**Recommendation:** Refusal

**Applicant:** Mr Graham Vint

**Proposal:** Single storey kitchen extension

Client Mr and Mrs G Vint Hornton Grounds Stratford Road Hornton Banbury OX15 6HH	Job Proposed single storey rear Kitchen extension (Existing)	Scale 1:50 and as shown @ A1
		Date June 2021
		Dwg No 01

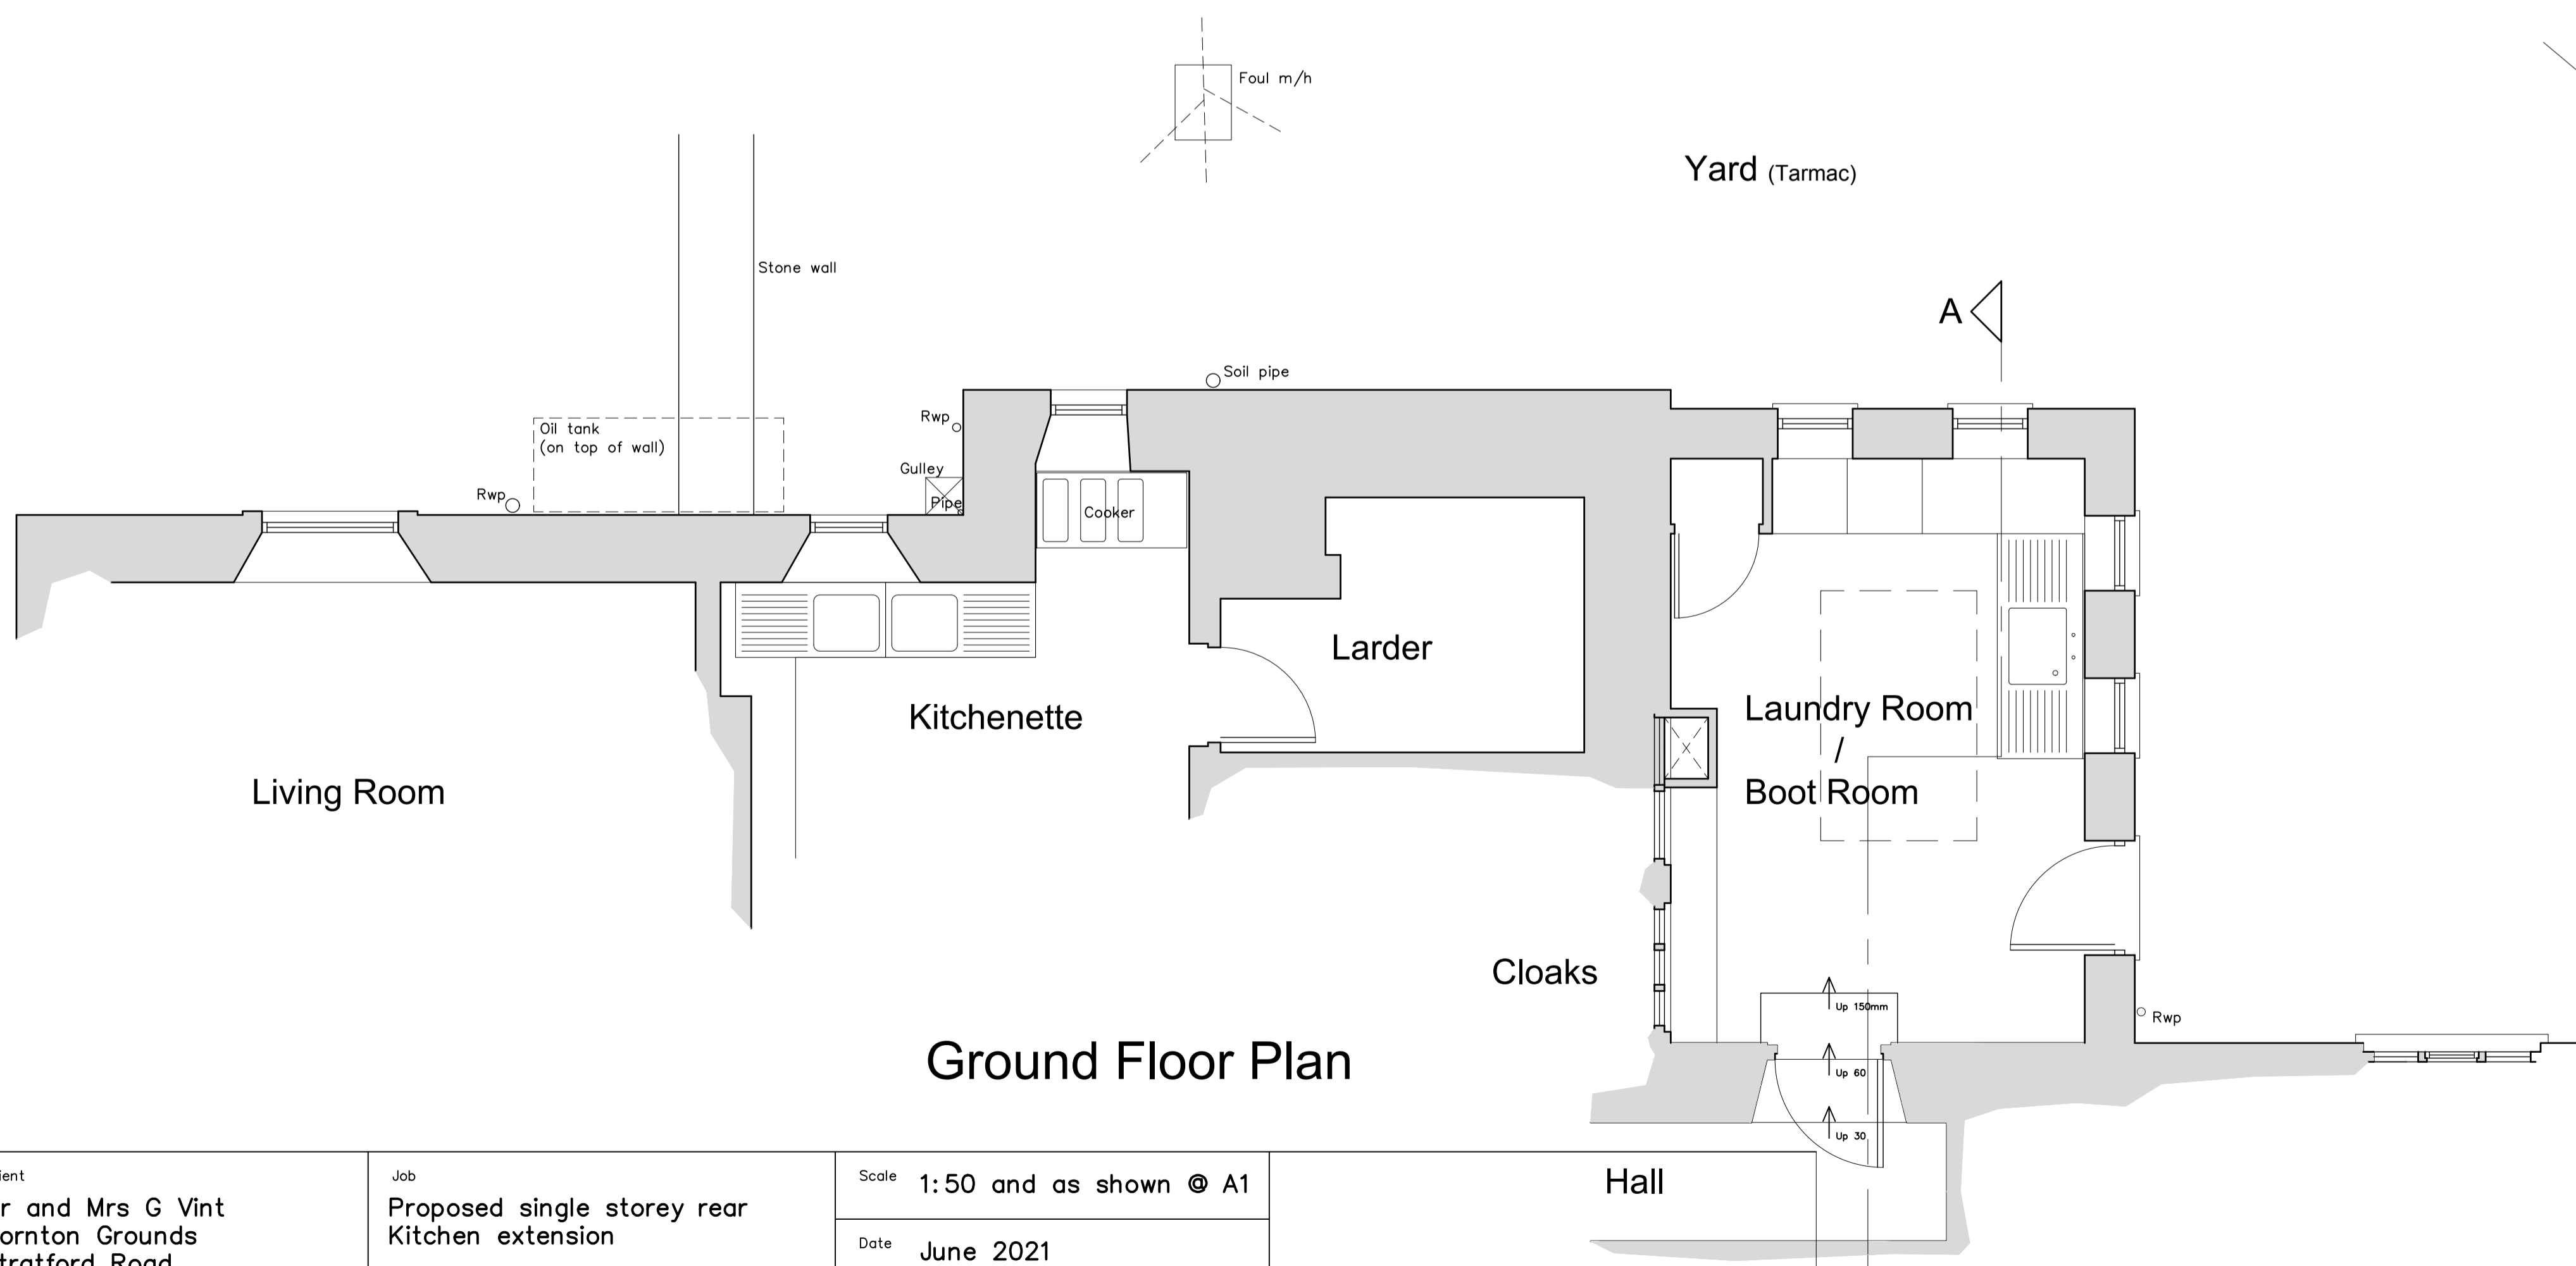
*We need full plans of the ground floor and full elevations of the principal west elevation, the north and east, as existing and as proposed. This would allow a full analysis of the proposals. We also need a phasing plan to understand the historic development of the large farmhouse. The 2009 LB application includes unlabelled plans of the ground floor in two parts, I joined these in photoshop to help with my understanding of the full plan but this does not include the 2013 extension. There is a very strong line which runs through, we need to understand the significance of this as the proposals look to remove part of this wall.*

The application does not include a full layout of the existing building in plan form – just an excerpt showing the adjacent areas. It is not clear where the existing kitchen is and what the overall impact on the plan form would be. A heritage statement was submitted with the application, but this document falls short of a full assessment of the impacts and does not justify the proposals.

Scale 1:50 and as shown @ A1
Date June 2021
Dwg No 03

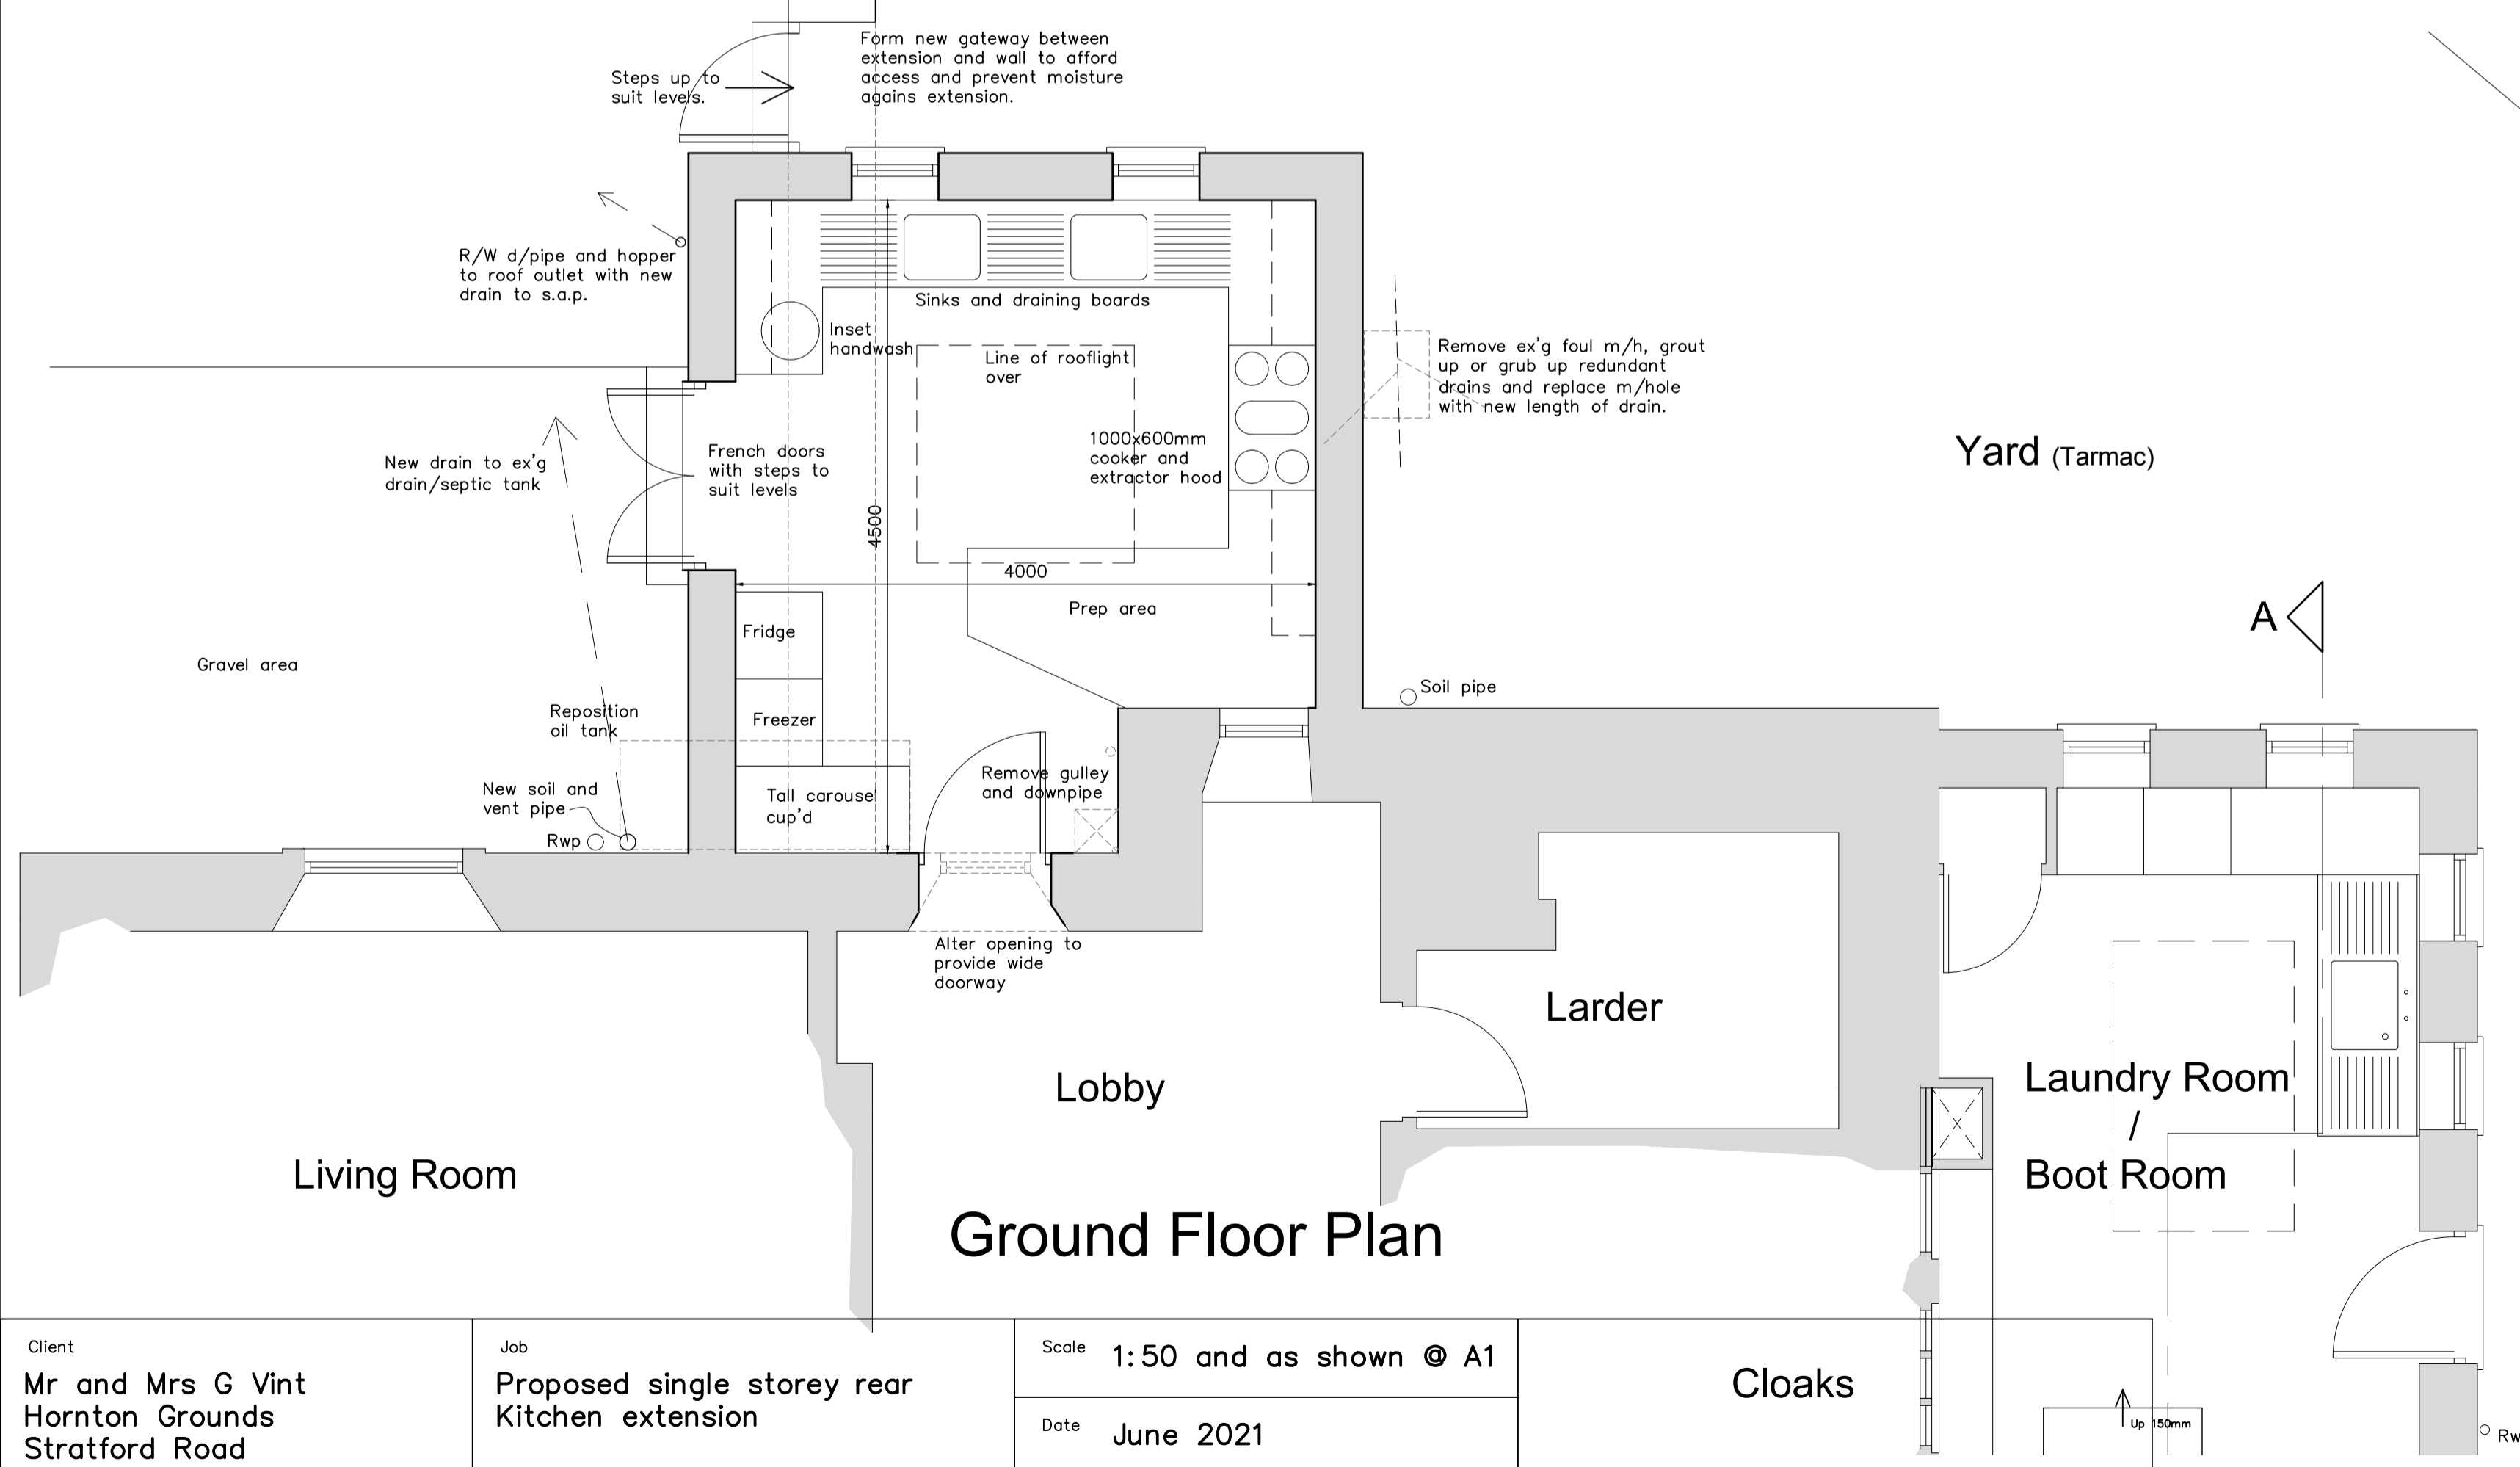
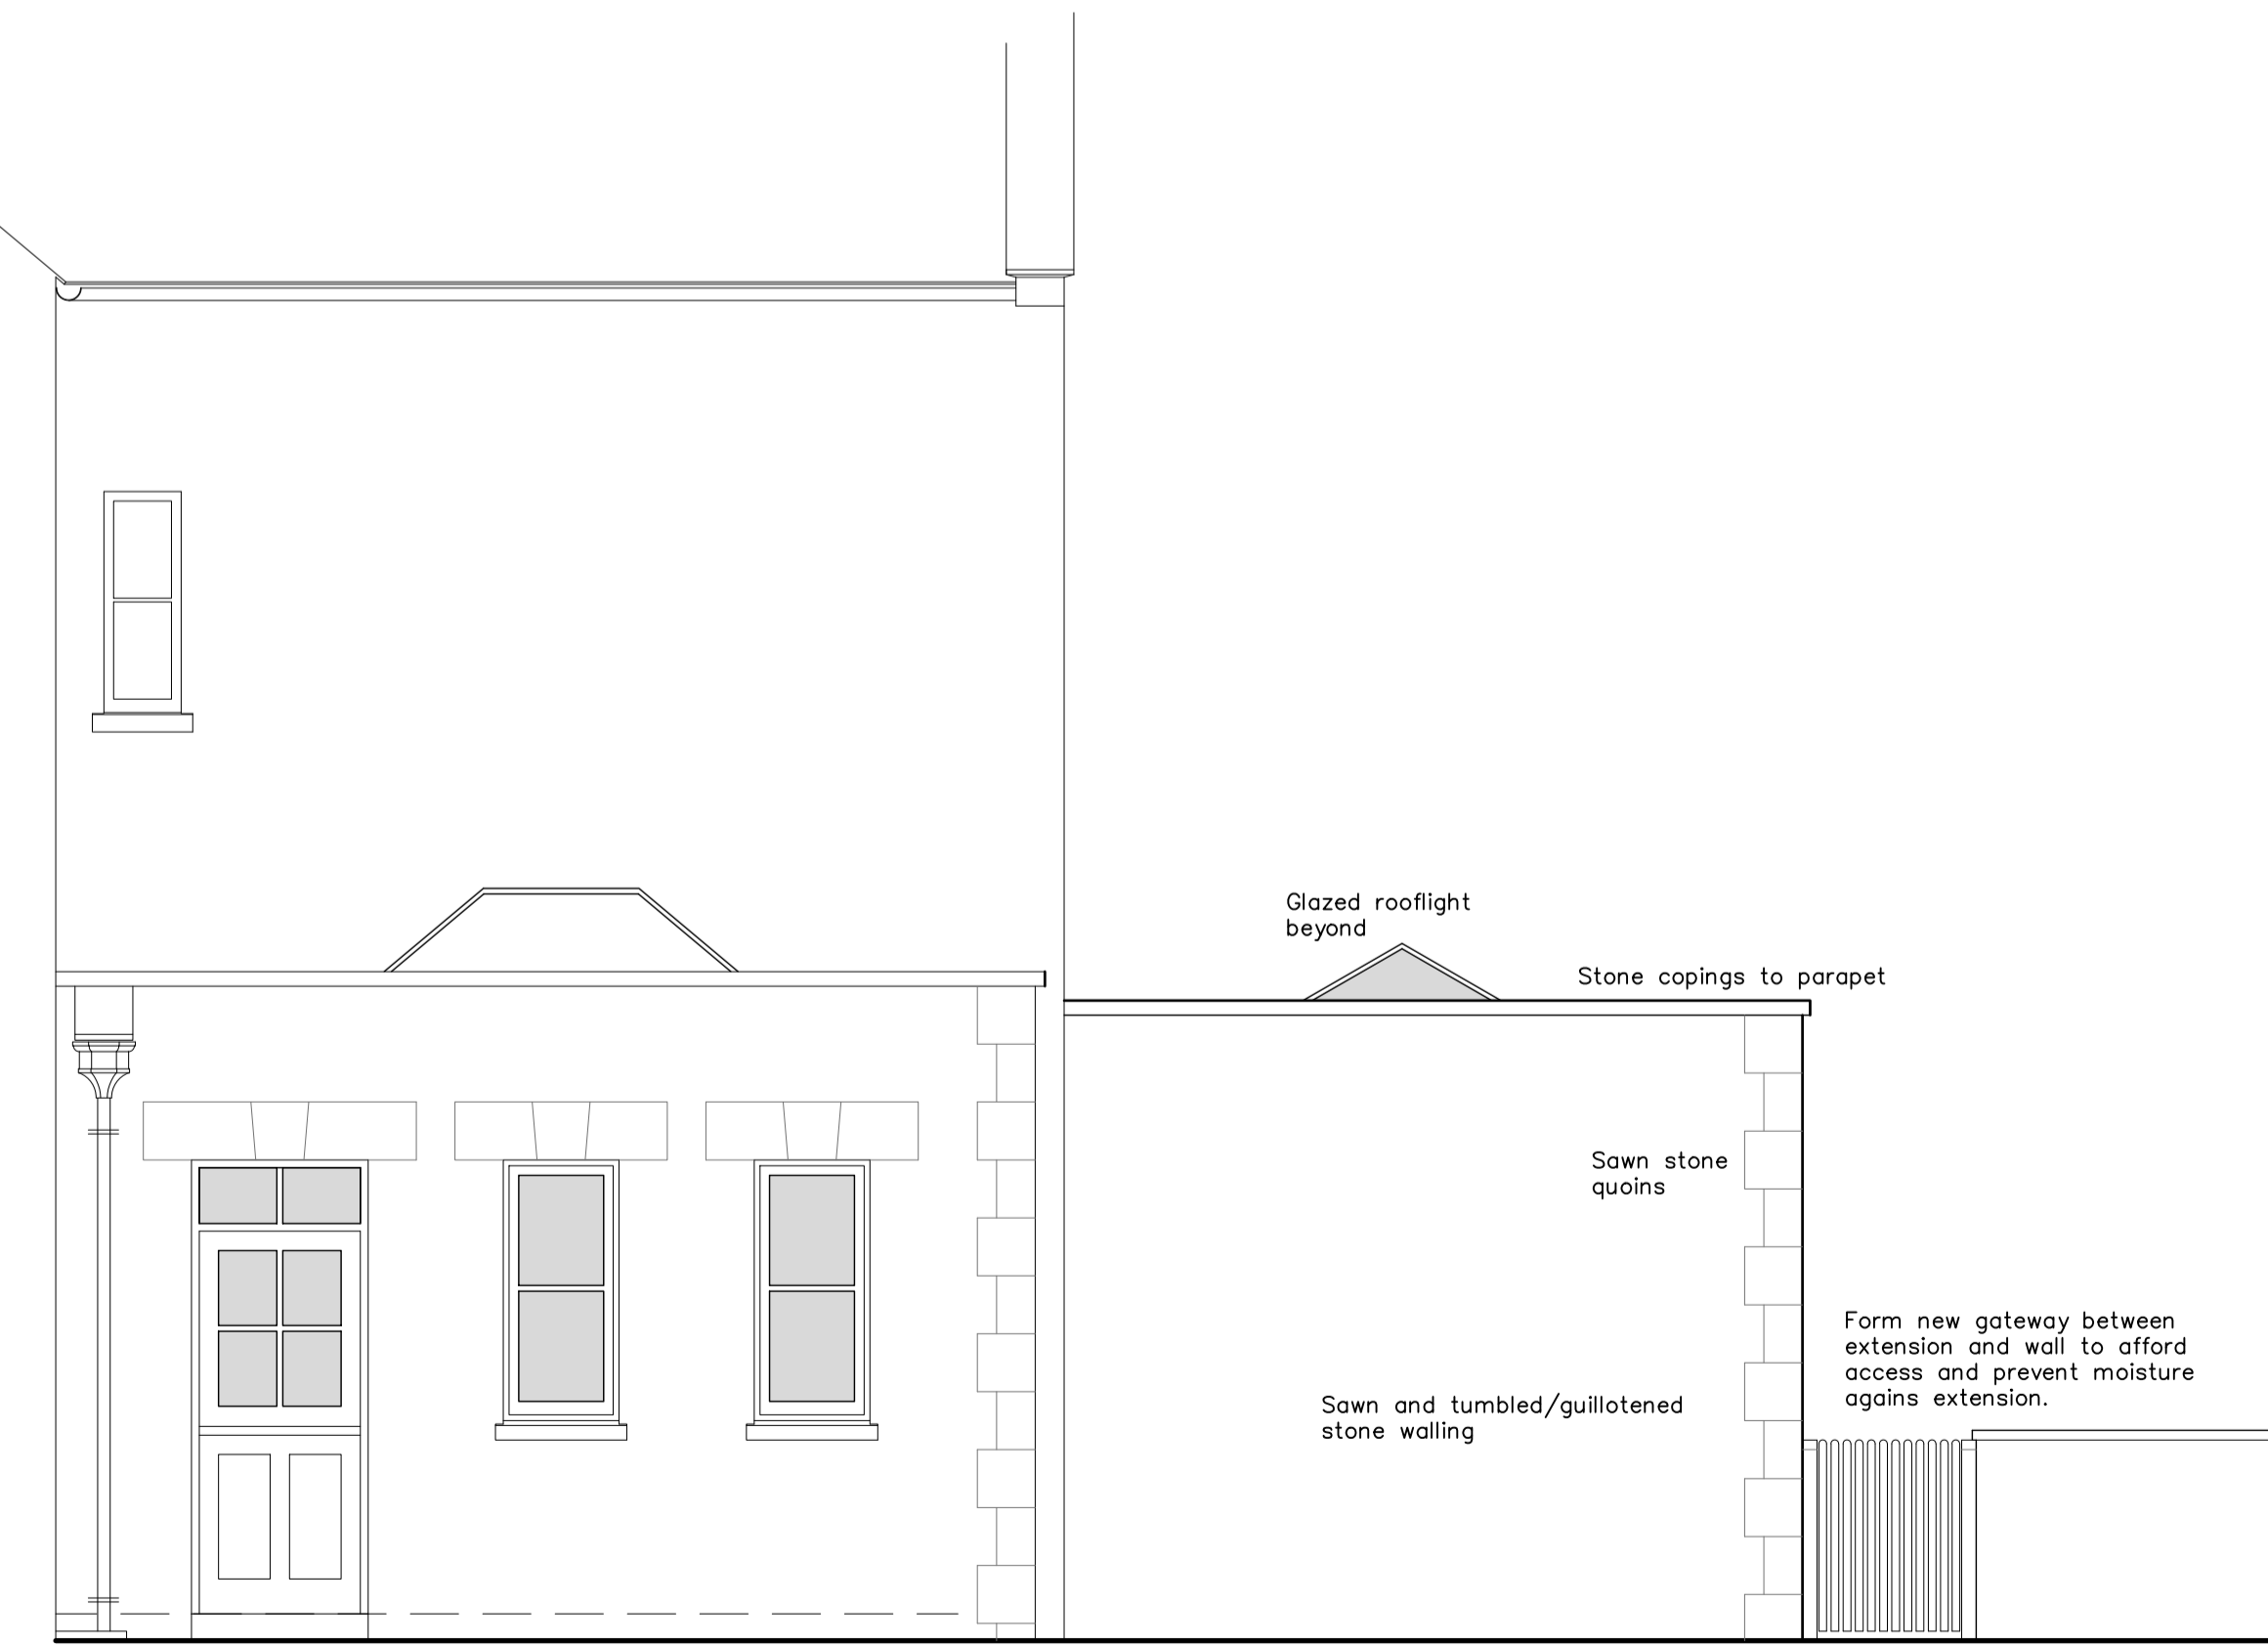
*The significance of the wall that projects northwards from the north elevation of the farmhouse and encloses the farm/livery yard is not understood, the proposed extension does not respect the line of the wall and we should not encourage any extension west of this line. The proposal also straddles two phases of building and does not respect the corner of the pre 1875-87 north wing.*

The proposed extension would introduce a structural element outside of the existing northern side elevation of the host building – disrupting the historic pattern of development. The building would also straddle two earlier phases of the building, causing a visual imbalance – muddying both distinct styles with a third phase of construction.

The proposed extension would also result in the opening-up of a separating wall internally and the historic plan form of the existing building would be disrupted. Insufficient information on the layout and phasing of the building has been submitted with the proposals to fully assess this impact. In light of the absence of information it is considered that this would also result in less than substantial harm to the significance of the building due to the disruption in the layout.

The proposals are considered to amount to a less than substantial harm to the significance to the designated heritage asset, due to the incongruous design, the proposed location beyond the existing envelope of the built-form and the fact that the proposed structure would straddle two separate earlier phases of construction.
